Your Ref: OWPC3503
Our Ref: EG/57/14/A 11-07-2014
Please ask for:
Mr S Davis

1 No internally illuminated fascia sign, 1 No externally illuminated fascia sign, 1 No externally illuminated projecting sign, 2 No non illuminated wall mounted dibond panels on front elevation.

The Barnham Hotel 28 Barnham Road Barnham

PROPOSED FRONT ELEVATION

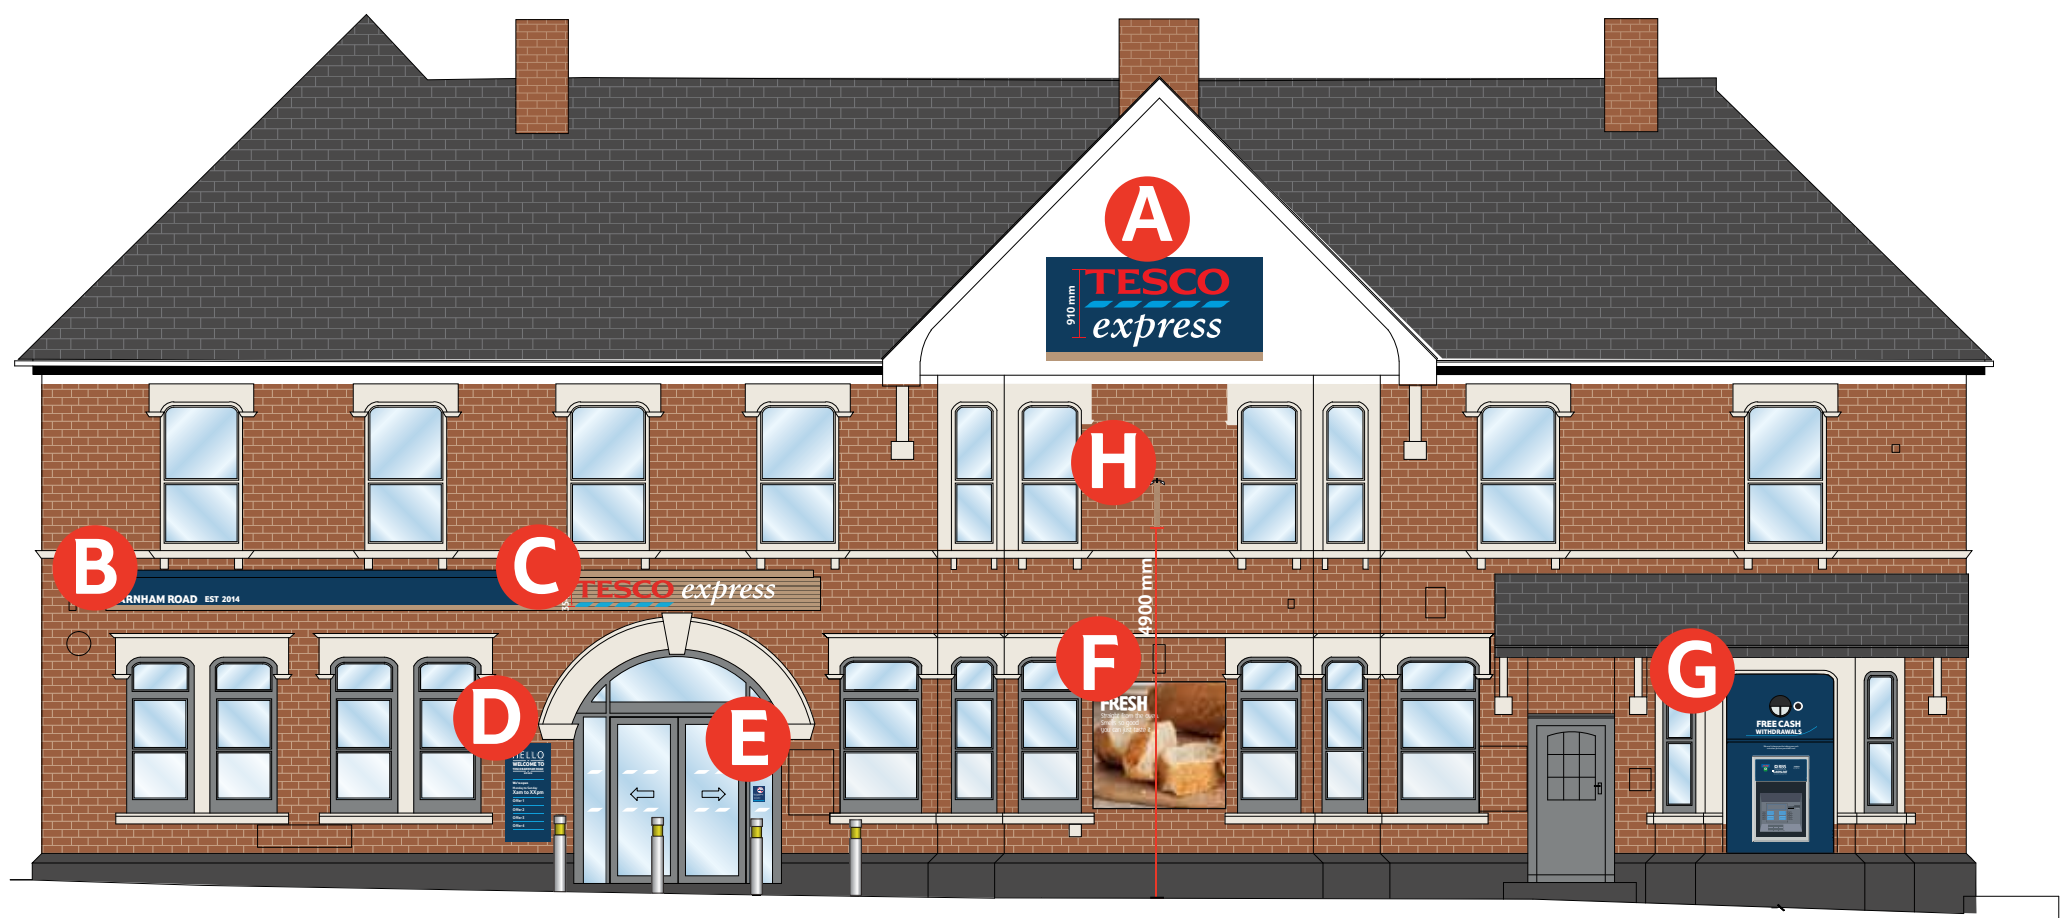
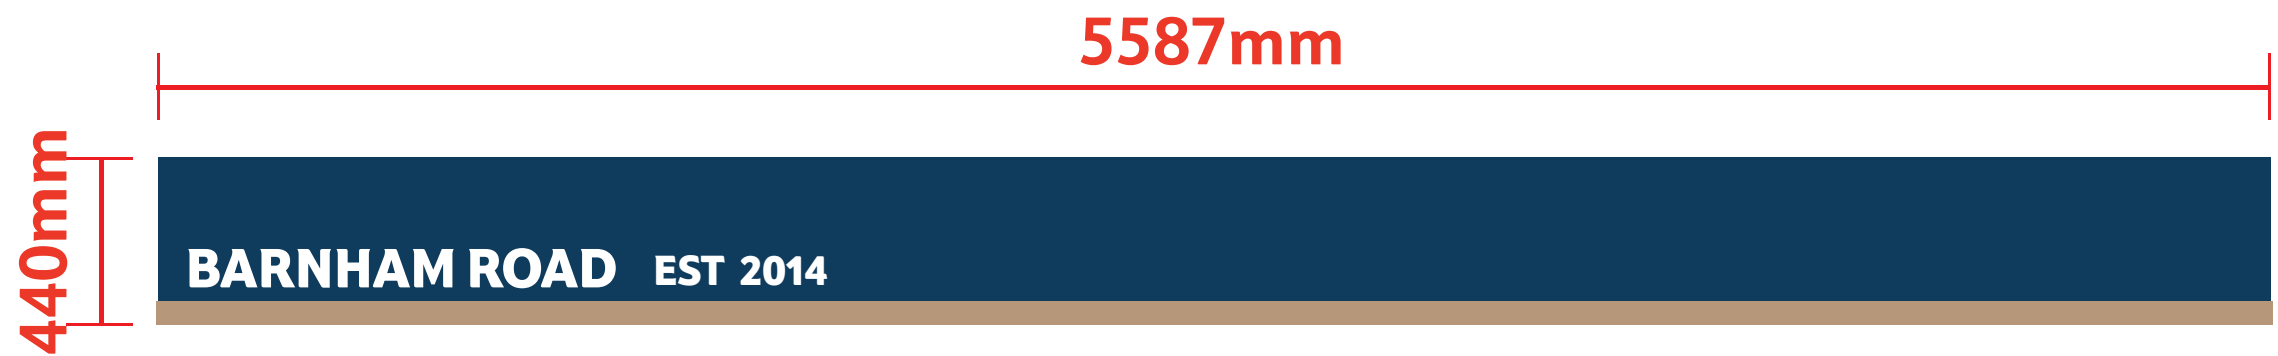
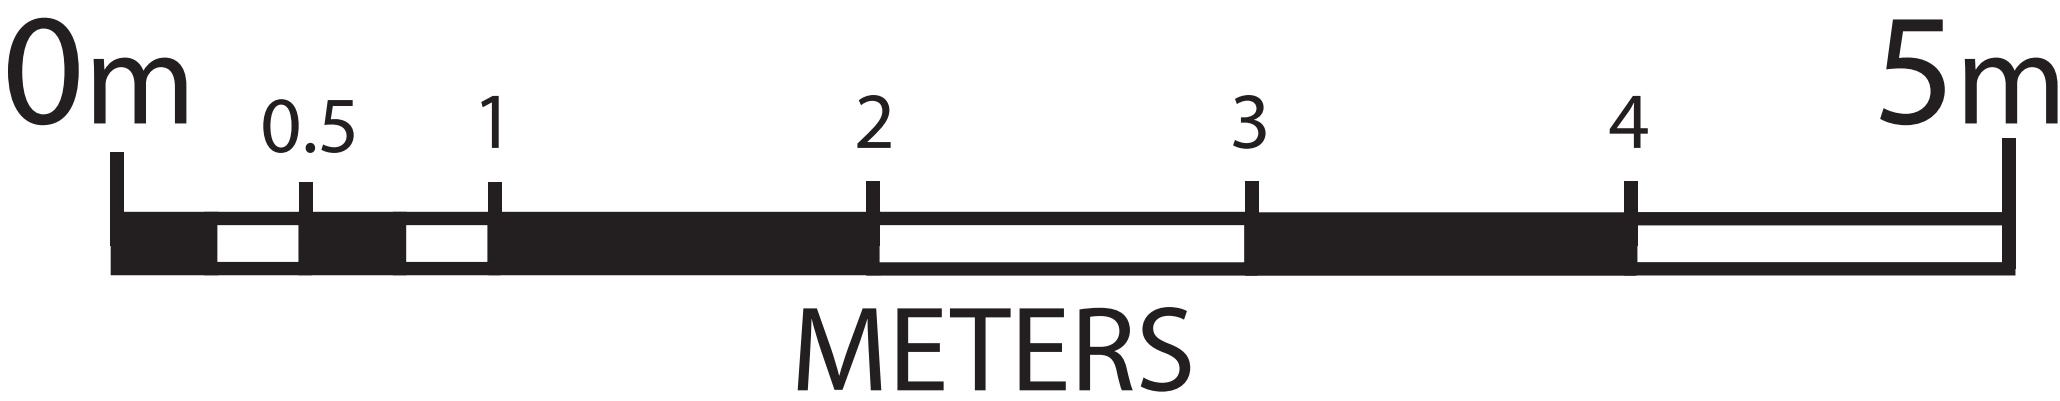
Any external illuminated signage would not be in keeping with the look and feel of Barnham. Light pollution would also an issue.
